Appeal Decision

Appeal Ref: 6003268

166 Barnsley Road, Darfield, Barnsley S73 9DQ

- The appeal is made under section 78 of the Town and Country Planning Act 1990 (as amended) against a refusal to grant planning permission.
 - The appeal is made by Sawaran Singh Mawi against the decision of Barnsley Metropolitan Borough Council.
 - The application Ref is 2025/0807.
 - The development proposed is change of use of property from dwelling (C3 use) to use as a seven person house in multiple occupation (sui generis use).
-

PLANNING
 PROPOSED
 PLANS AND ELEVATIONS

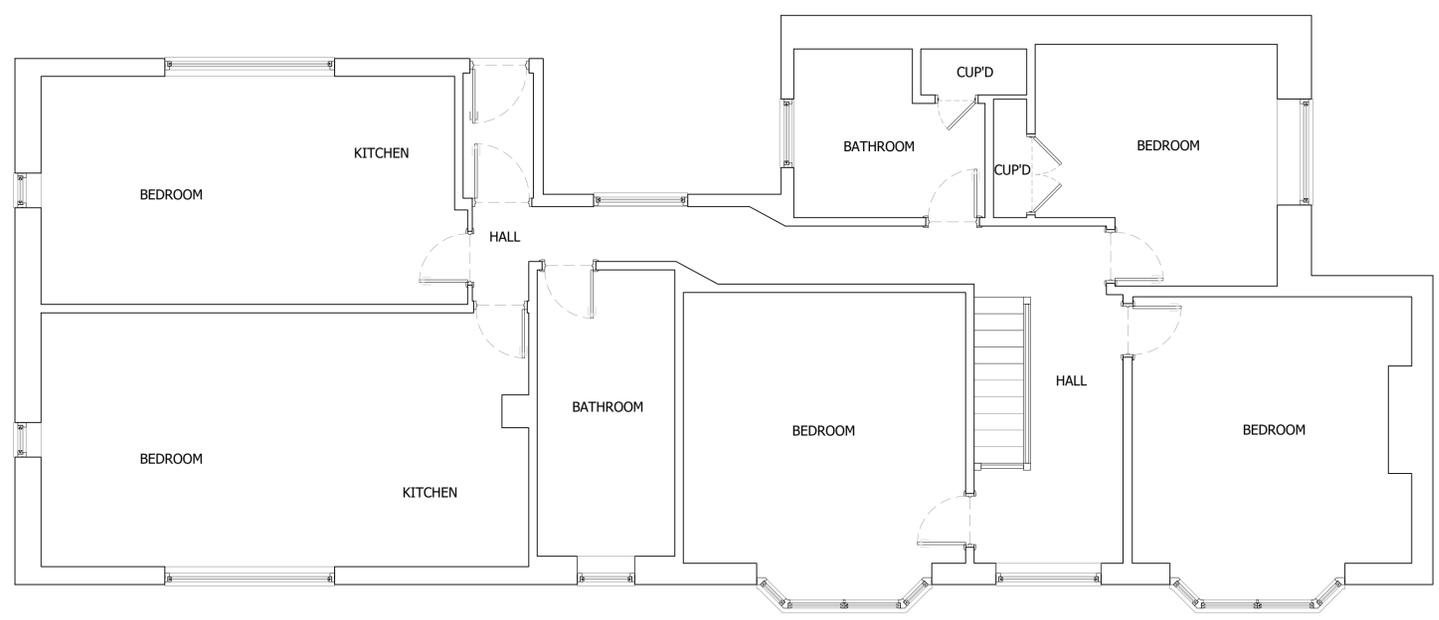
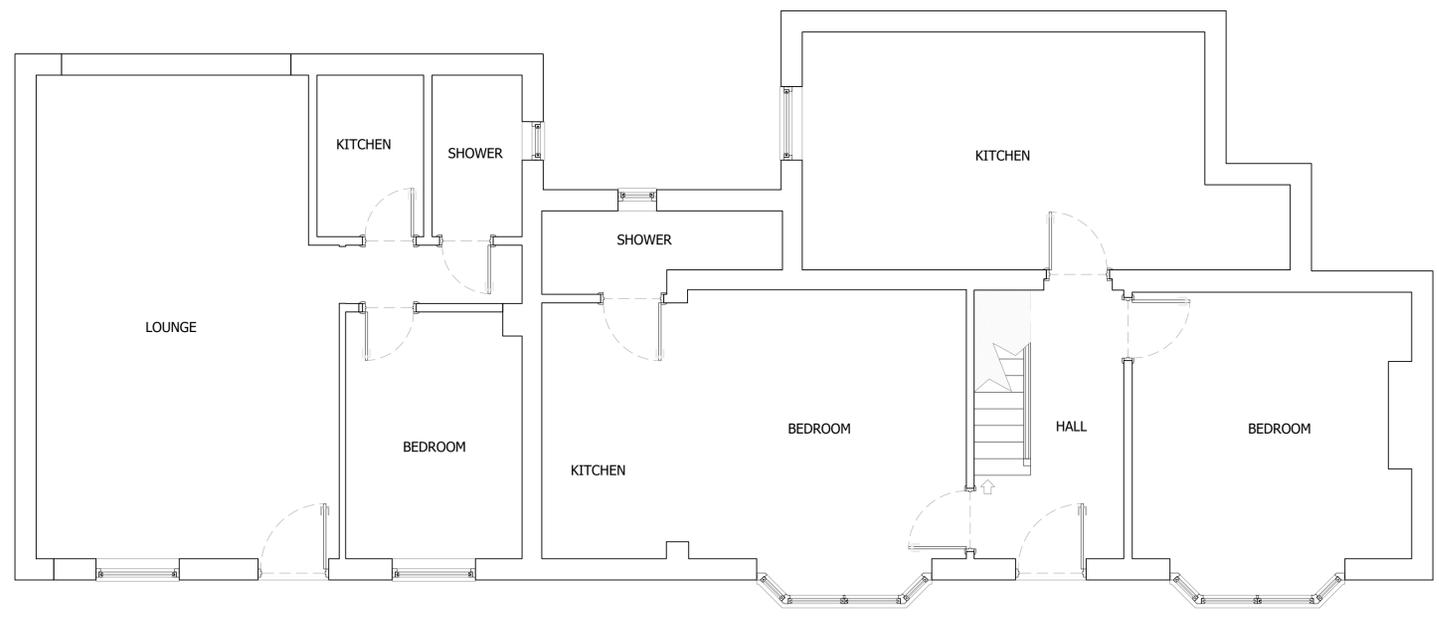
5. The submitted plans show that two bedrooms are located on the ground floor and five on the first floor. Communal facilities comprise a kitchen at ground floor level and two bathrooms on the first floor. Three of the bedrooms adjoin private kitchen areas and one of these also incorporates a shower room.

6. The Council's assessment of the bedroom sizes concluded that, while all meet the South Yorkshire Residential Design Guide (RDG) standards for single occupancy, two do not meet the 12 square metre standard expected for double occupancy. As the description of development refers to a seven-person HMO and seven bedrooms are shown on the submitted plans, I am satisfied that occupants are afforded satisfactory private space in accordance with local bedroom-space standards. Were the appeal to be allowed, a condition could secure an appropriate maximum occupancy.

7. Although the Council refer to standards within the RDG relating to communal living areas, I have not been directed to the specific requirements. Nevertheless, I do not consider the size or configuration of the kitchen to be capable of providing sufficient communal living space alongside its intended cooking, dining and utility functions. As a result, occupants are likely to rely on their bedrooms to serve both living and sleeping purposes.

8. I recognise that three of the bedrooms benefit from additional private facilities. However, this is not the case for the remaining four bedrooms. The shortfall in communal living space is particularly acute for occupants of the two smallest bedrooms. The existence of a HMO licence does not overcome the harm arising from the internal configuration of the property, nor does it render the arrangement acceptable in planning terms. I therefore find that the internal living conditions to be unacceptable.

16. The appellant acknowledges that two off-street parking spaces are provided within the site, which falls short of the minimum expectation of four spaces set out in Barnsley's parking standards. Although it is not indicated on any of the submitted plans, the current configuration of the driveway does not enable vehicles to enter and exit the parking spaces in forward gear.
